Consultation Response from KC, Highways Development Management

2021/94280 land at Lady Ann Road, Soothill, Batley, WF17 0PY

Erection of 65 dwellings with associated works

Date Responded: 31/03/23

Drawing no: 10703-SELF-P-ZZ-A-M3- 001
Rev: N

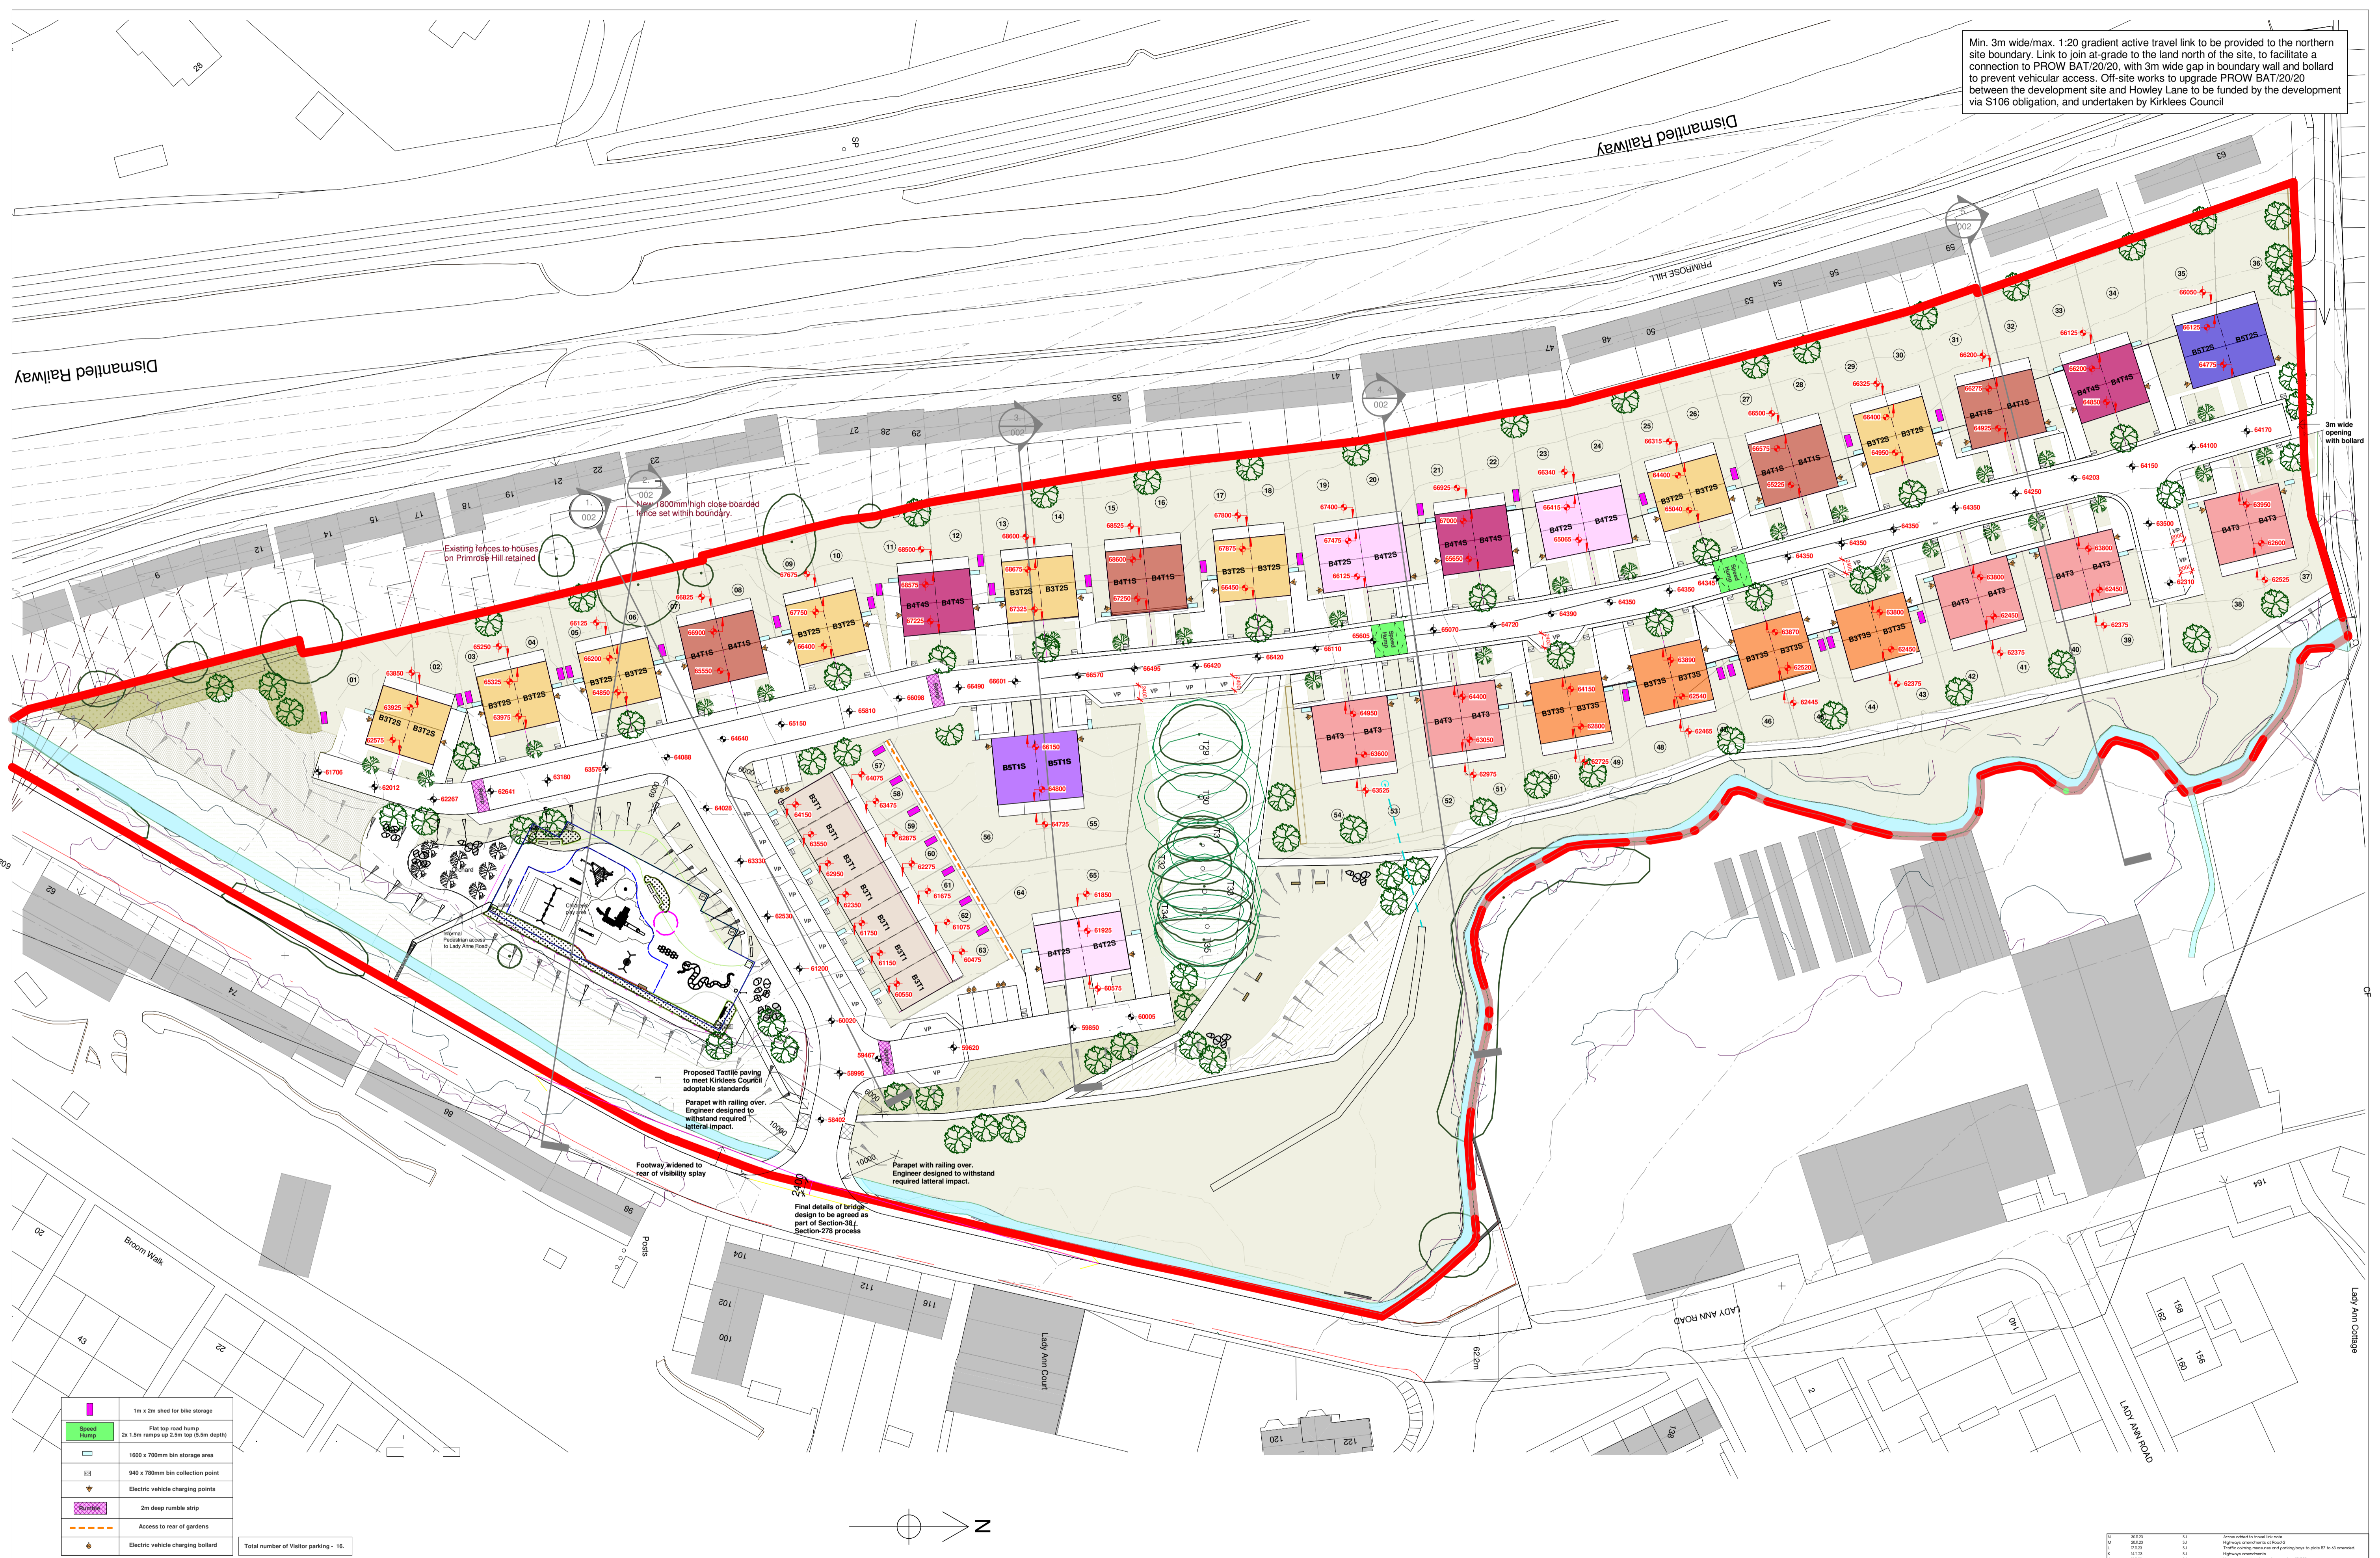
- At the internal priority junction opposite plot No. 6-7, 2.4x25m visibility splays have been shown. However, the splay to the north (it is noted that the plans shown north incorrectly) is restricted by the private parking spaces for Plot 57-59, and the subsequent visitor parking layby. This is not acceptable, and all visibility splays must be contained within the adopted highway and should not be blocked by parked cars.

- The road alignment between plot no. 1 to no. 36 is long and straight for circa 300m, which is likely to encourage high traffic speeds. This is not acceptable, and some form of speed reducing features must be incorporated, which may be vertical deflection features such as ramps, or landscaped buildouts etc. To achieve the required design speed of 20mph, speed reducing features should have a maximum spacing of 60m.

- The width of the visitor parking laybys have not been confirmed. However, these must be a minimum of 2.4m wide when adjacent to hard margins (2.0m is only acceptable when adjacent to a footway).

- Bin presentation points adjacent to the highway have not been shown. These need to be provided to ensure that private drives and paths are not blocked by bins on collection day, which is particularly important for the shared private drives and shared surface roads. It is noted that the bin carry distance for Plot 1 is in excess of 25m, which is not in accordance with standards. As such, the bins presentation points should be reviewed. The other comments relating to waste collection provided by the Councils Waste Strategy team dated 11/1/2023 should also be addressed.

- The private drives in front of plot no. 1 & 2 seems tight in width. This should be a minimum of 4.5m, and Swept Path Analysis (SPA) should be provided to confirm that the adjacent parking spaces are accessible.

- Rumble strips / ramps at the transition points at the start of private drives need to be introduced. Also, at the transition point between the traditional estate roads and the shared streets, rumble strips / ramps are required, and the footways need to extend beyond these features (See S38 standard details that confirm these requirements).

- There are a number of unadopted footpath links proposed at the site. A number of these links connect to the highway in appropriate locations, such as within the visitor parking laybys, which is not acceptable.

- As confirmed earlier in this response, the site access design on to Lady Ann Road is not acceptable in it's current form.
- As confirmed earlier in this response, a min. 3m bridleway connection is required at the north end of the estate road to connect to PROW BAT/20/20. This must be a ramped (max. 1:20 gradient) link, with no steps, and should include bollards to prevent unauthorised motor vehicle use.

- It is understood that Plot 57-63 are 3 bedroom units, so should be provided with 2 no. off-street parking spaces. However, only 1 off-street space per unit has been provided. Instead the applicant has proposed 7 no. layby spaces adjacent to these dwelling, which are contained within the adopted highway, and has suggested that these will be dedicated to these unit. This is noted acceptable, as these spaces cannot be dedicated to individual residents. Notwithstanding this, if these spaces were provided as shared communal spaces for all highway users, which could also be used by the adjacent residents, this may be an acceptable option (albeit this is not in accordance with the Councils Highway Design SPD). Therefore, the applicant should consider this matter further, and confirm how they wish to proceed in this regard.

- As previously stated, the 3 no. spaces proposed for plot 57-59 block visibility at the adjacent junction. This could be addressed by setting these spaces back, and then provided a 2m wide footway adjacent to the carriageway to contain the visibility splay (subject to the amendments to the adjacent visitor parking layby too).

- Whilst the provision of visitor parking laybys (13 no.) is welcomed, this provision is still below Council guidance (1:4 spaces are required e.g. 16 no. spaces). As such, additional visitor parking spaces should be provided. It would be beneficial if this included 2 no. additional visitor parking laybys in the turning head adjacent to plot No. 39 to ensure that the turning head will not be blocked by any parked cars.
